# CITY OF ALBUQUERQUE

PLANNING DEPARTMENT – Development Review Services

RE: **Andalucia Phase I – 6500 Coors NW**  
**Grading Management Plan and Grading and Drainage Plan**  
**Engineer's Stamp Date 8-31-2016 (File: E12D015D)**

**GRADING AND DRAINAGE PLAN**

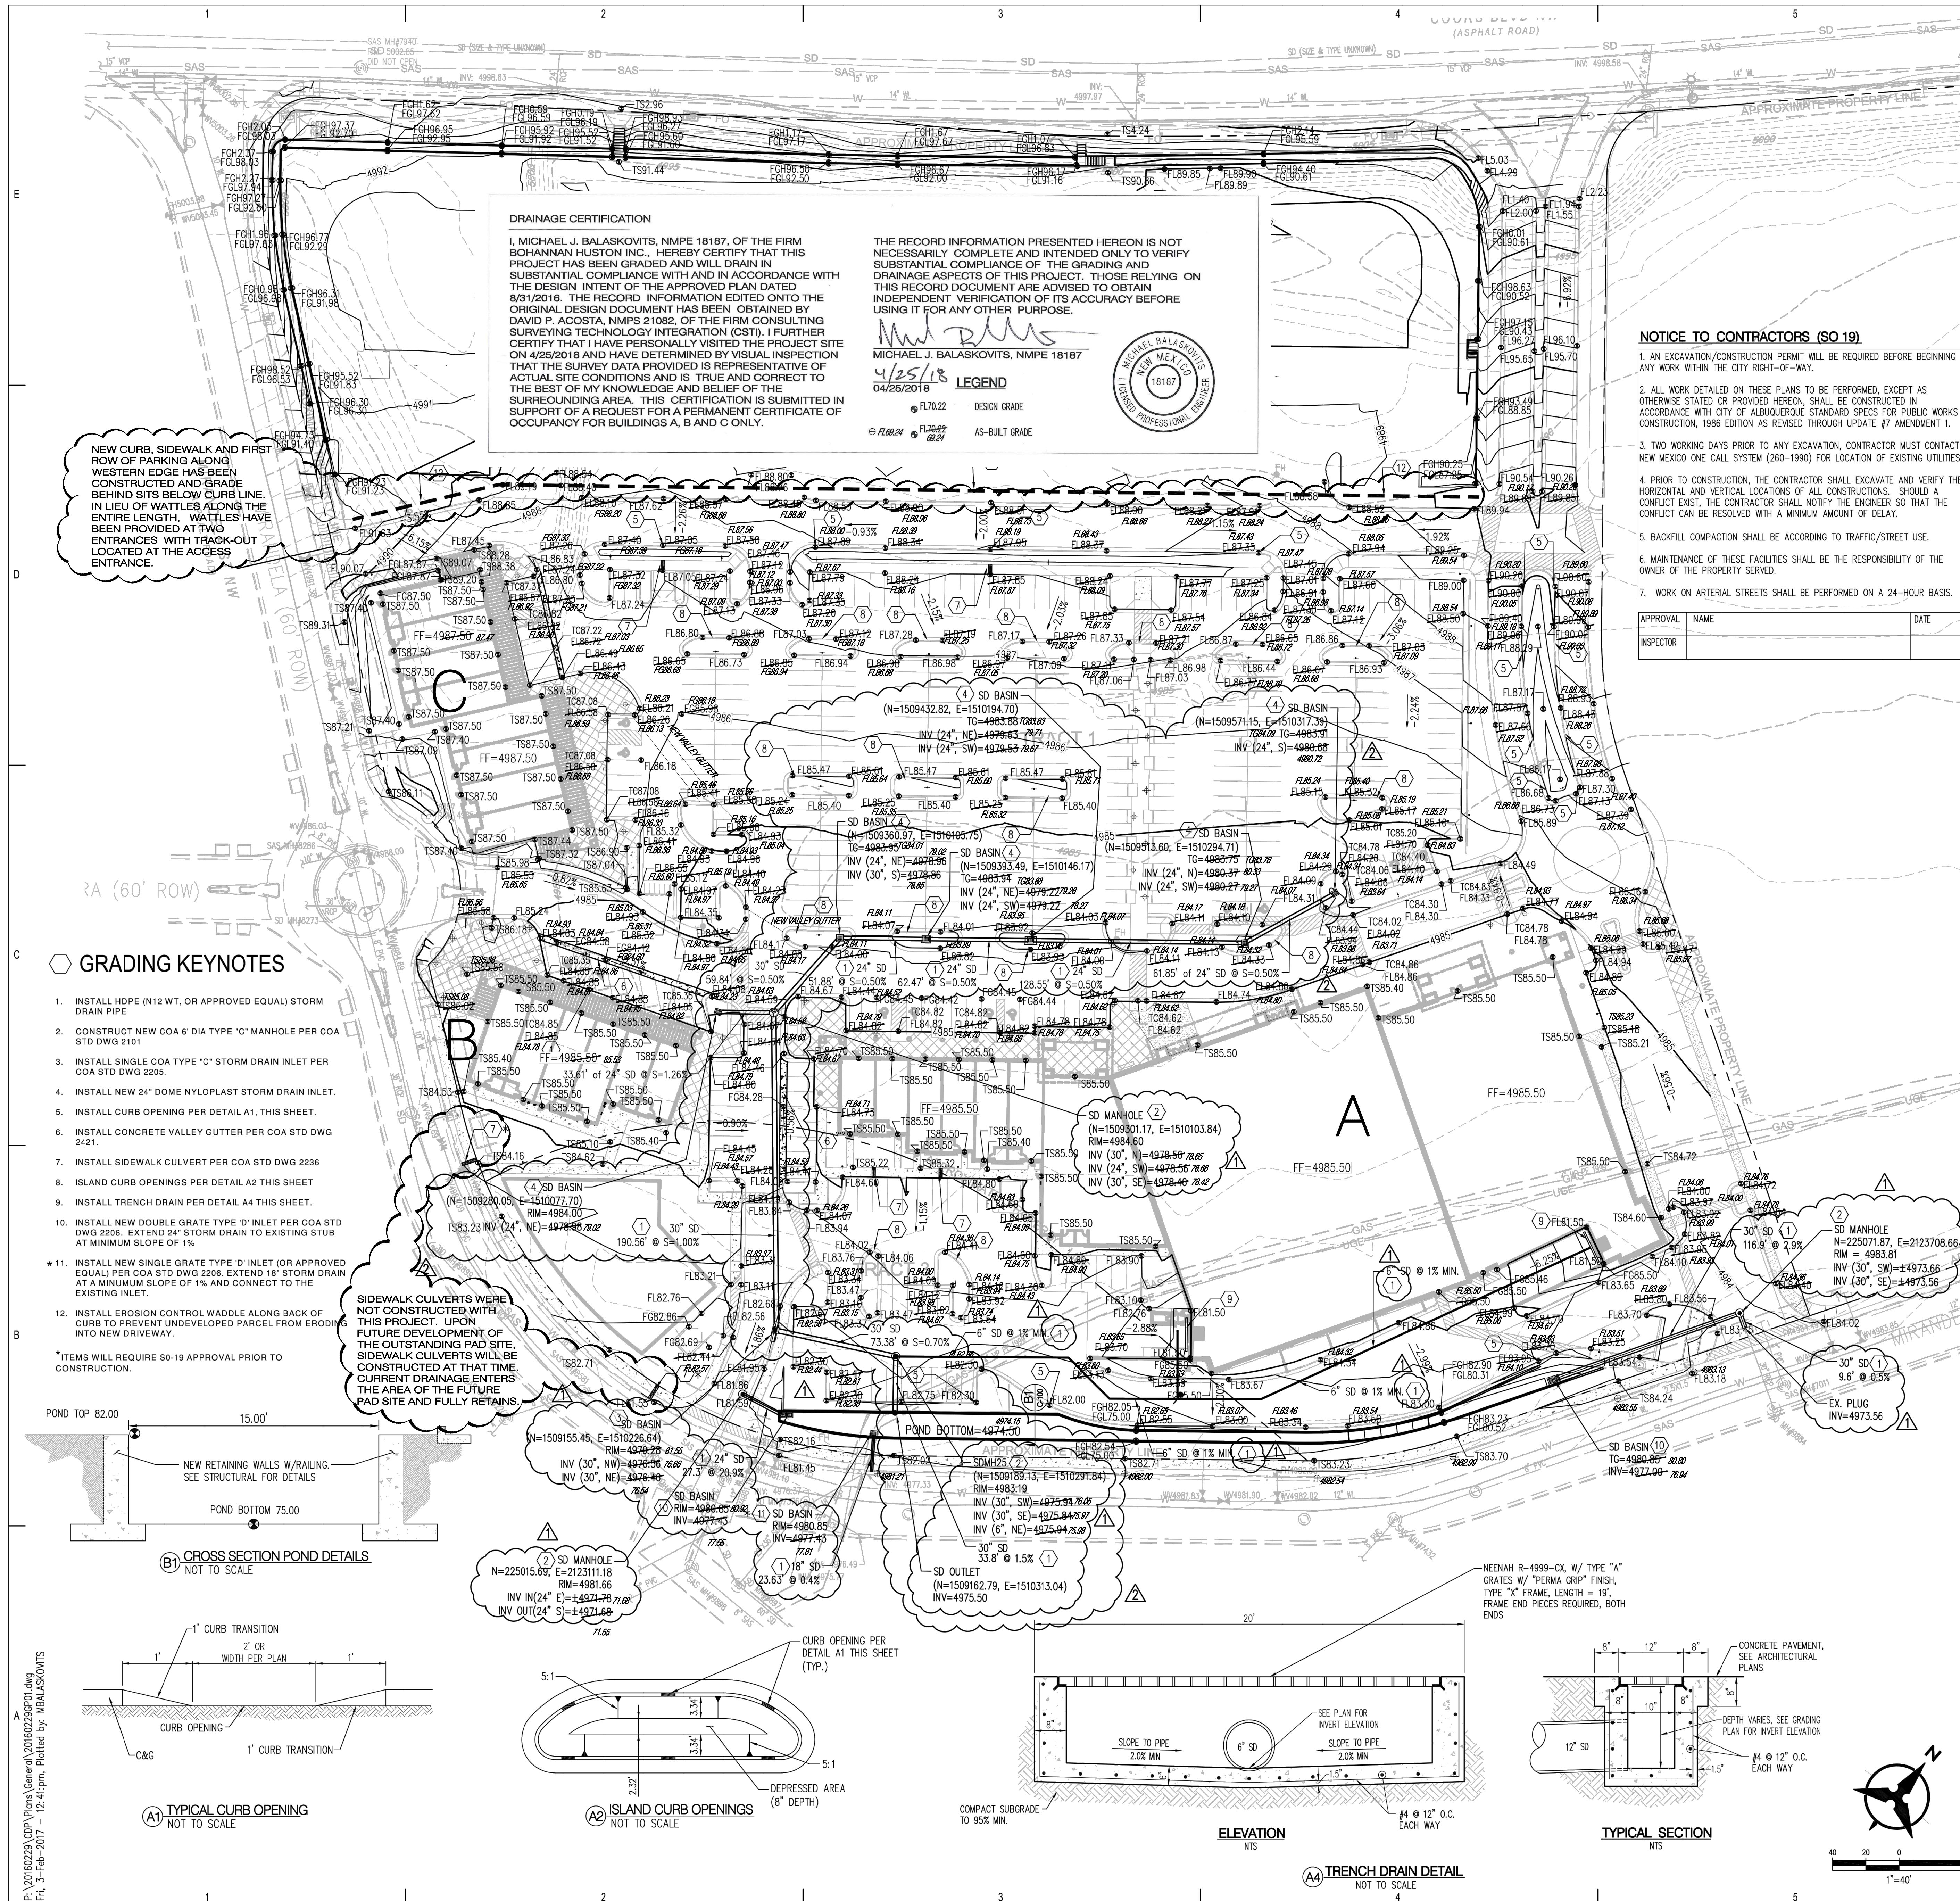
- The bottom of the pond will need to be lowered to 74.50 to allow for 0.5 ft of freeboard. The inlet grate elevations will need to be lowered (80.85), as well as the corresponding inverts.
- Inlet at north side of pond-lower the inlet grate elevation to match the other inlets
- Provide curb openings along median on private road on north side of site
